**APPLICATION NO:** 23/00723/FUL/ADDINF

**DESCRIPTION:** Proposed erection of a stretch tent style marquee over a refurbished outdoor climbing structure and used to provide shelter from the elements, allowing climbing to take place in we weather and prolonging the life of the climbing structure.  
The marquee has been erected on a temporary basis (less than 28 days) to facilitate the works to the outdoor climbing structure. This application is for the long term retention of the marquee structure.

**LOCATION:** Oakwood Waterloo Road Wokingham

Top, Front and Side elevation drawing of canvass boulder covering at Oakwood Youth Challenge.

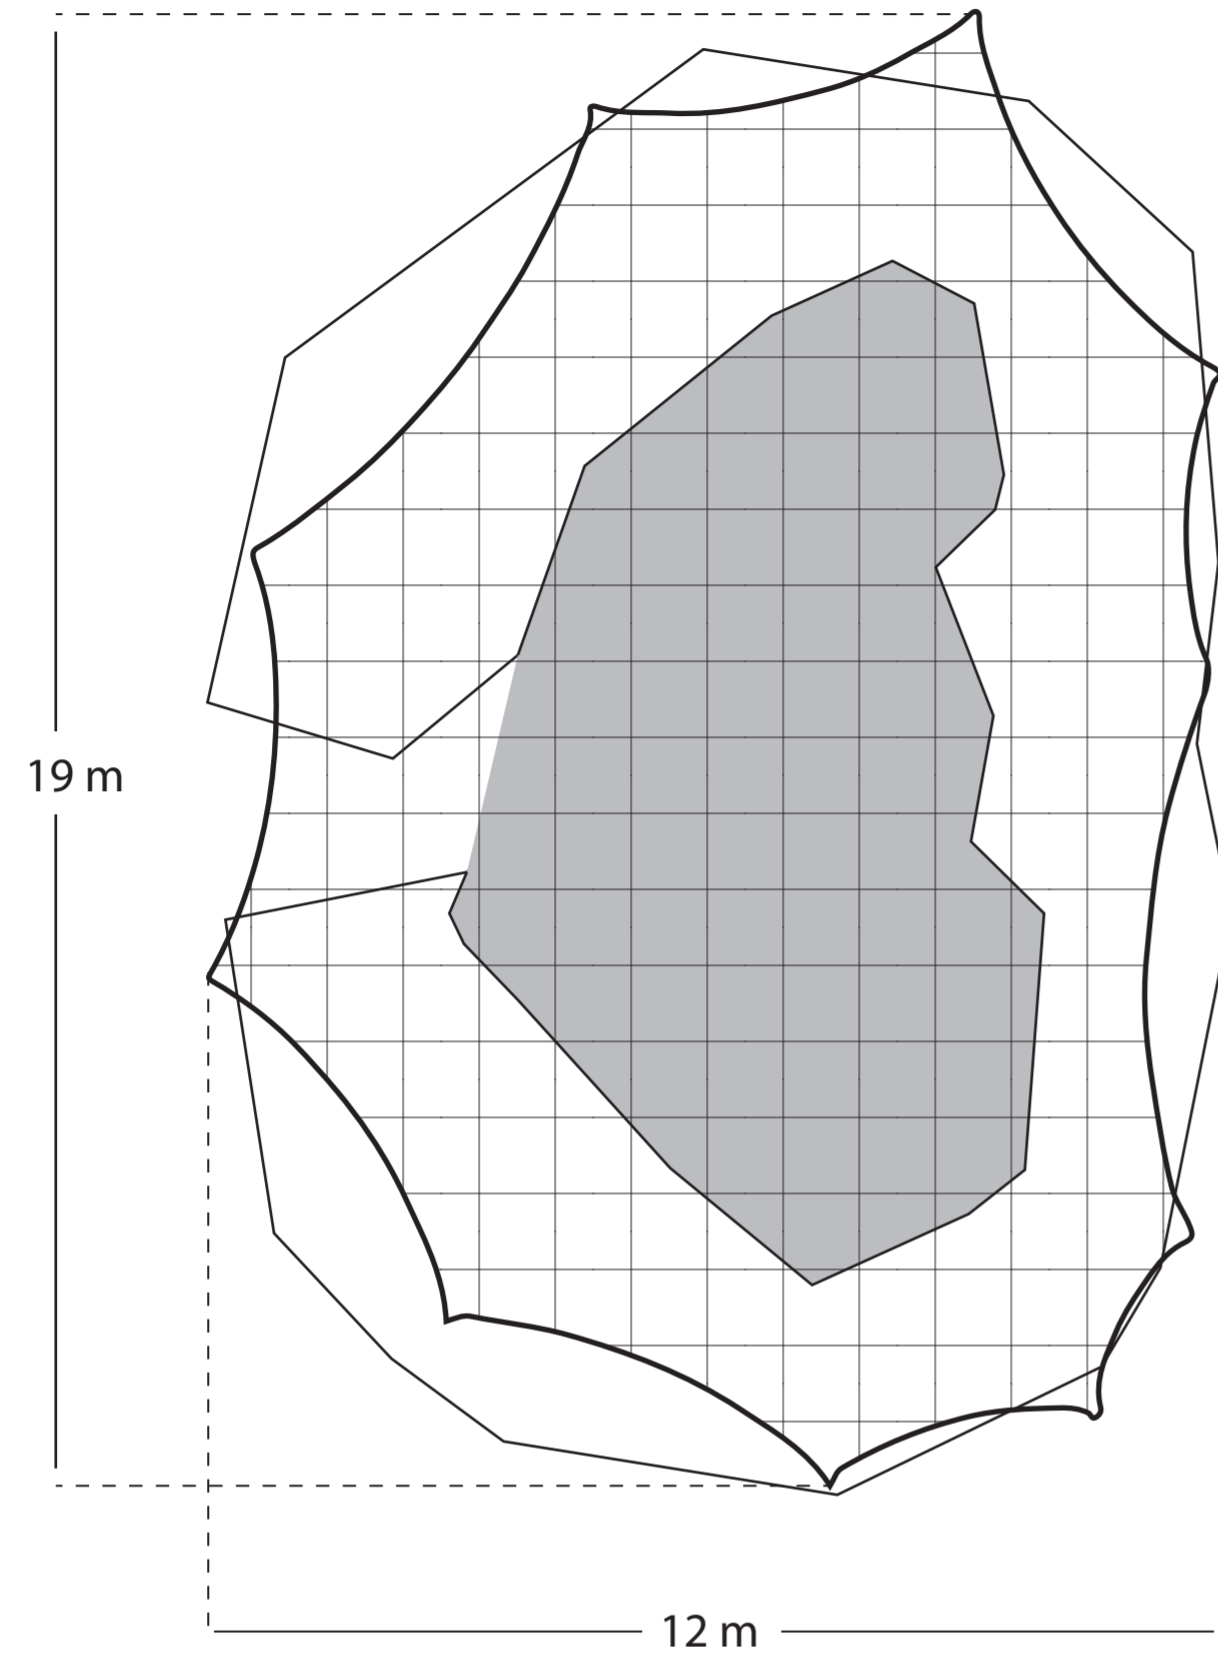
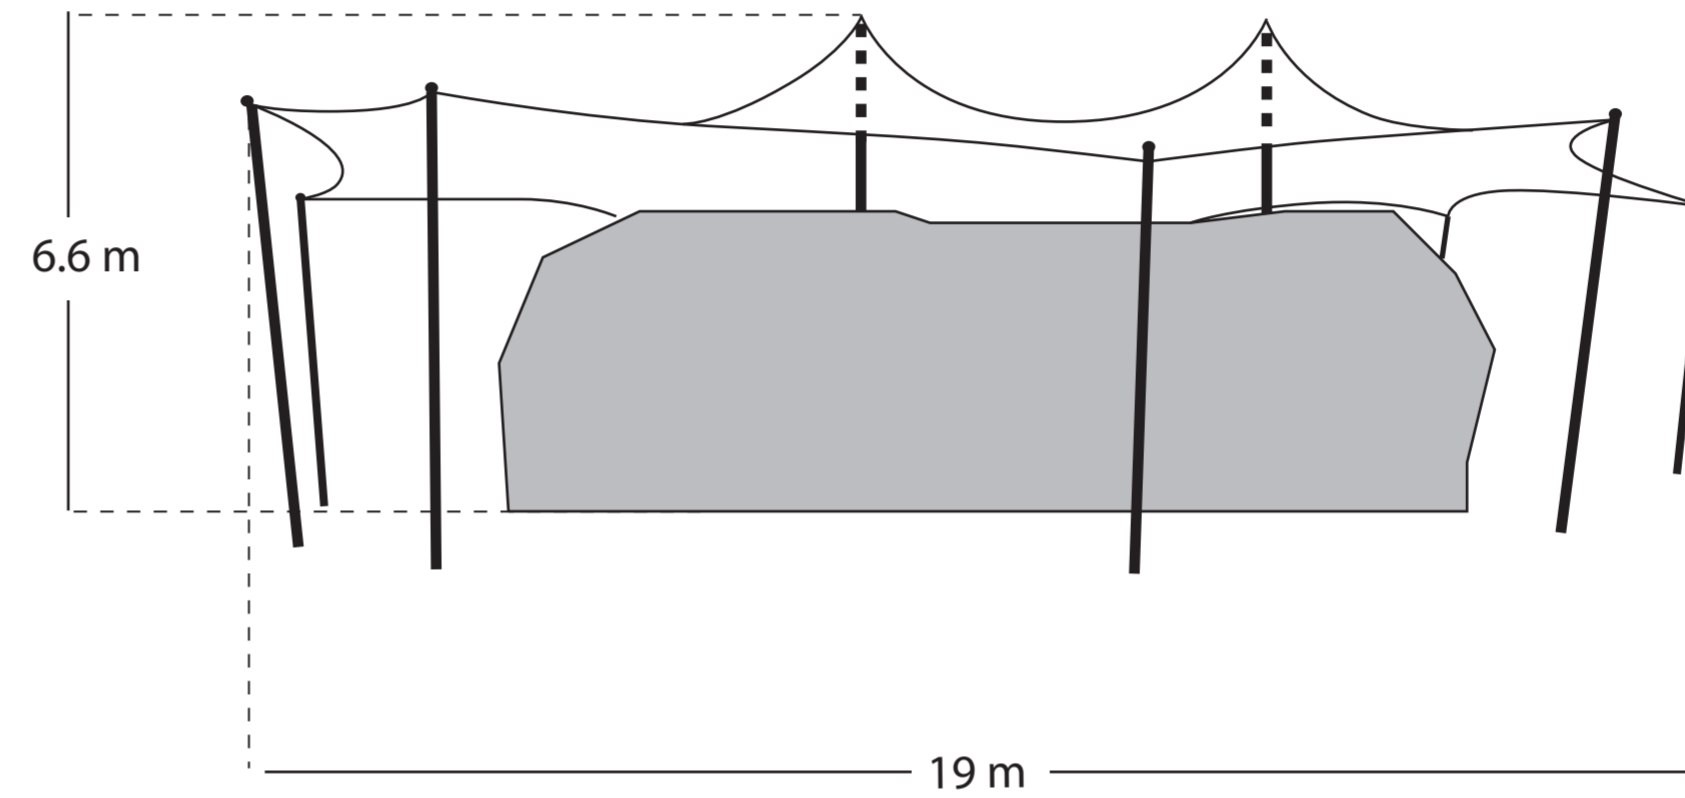
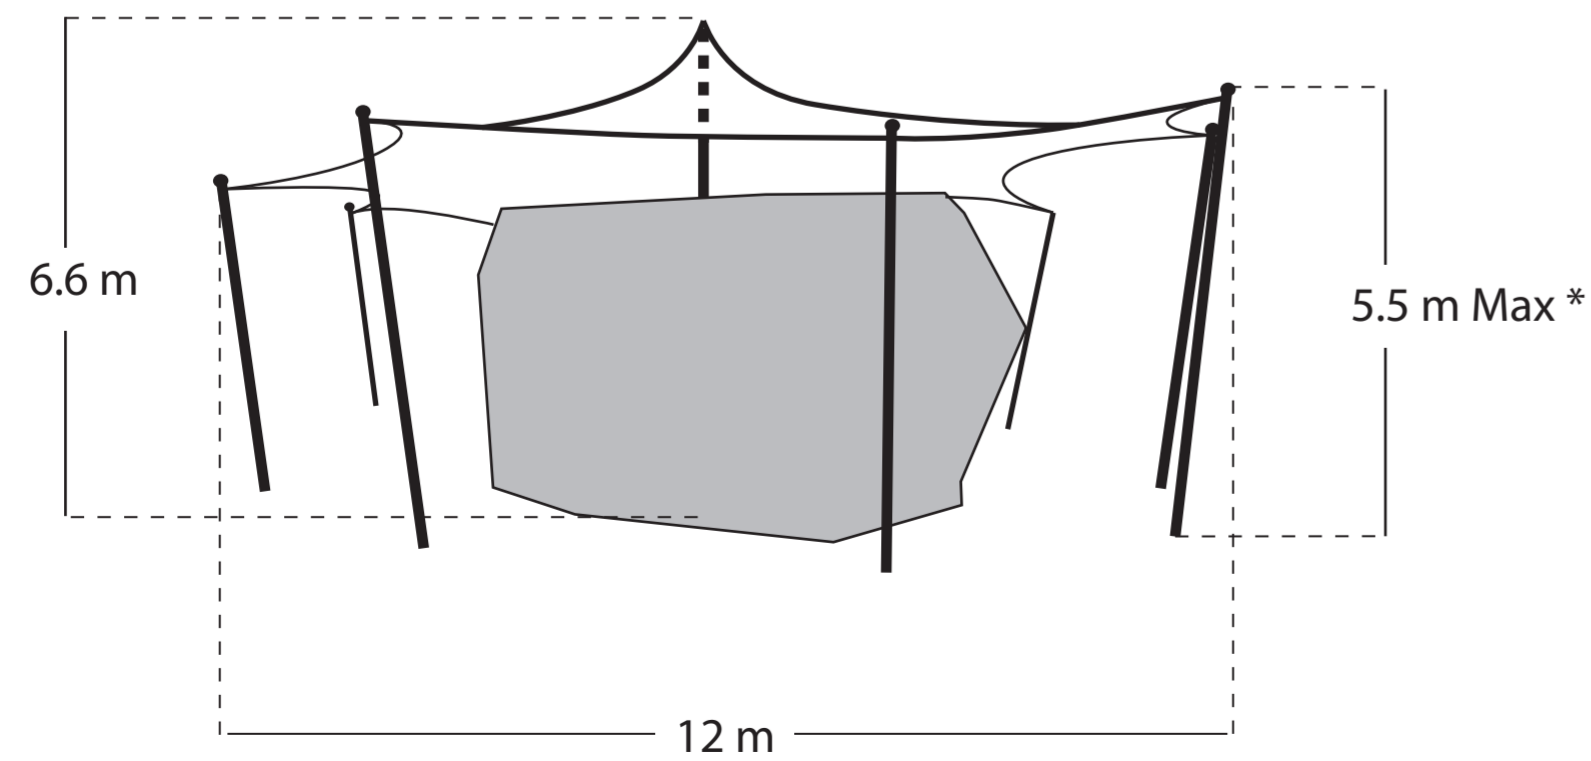
1. Please provide elevation drawings of the tent from all sides to a scale of 1:100 or 1:50.
2. Please provide a bigger scale floor layout.
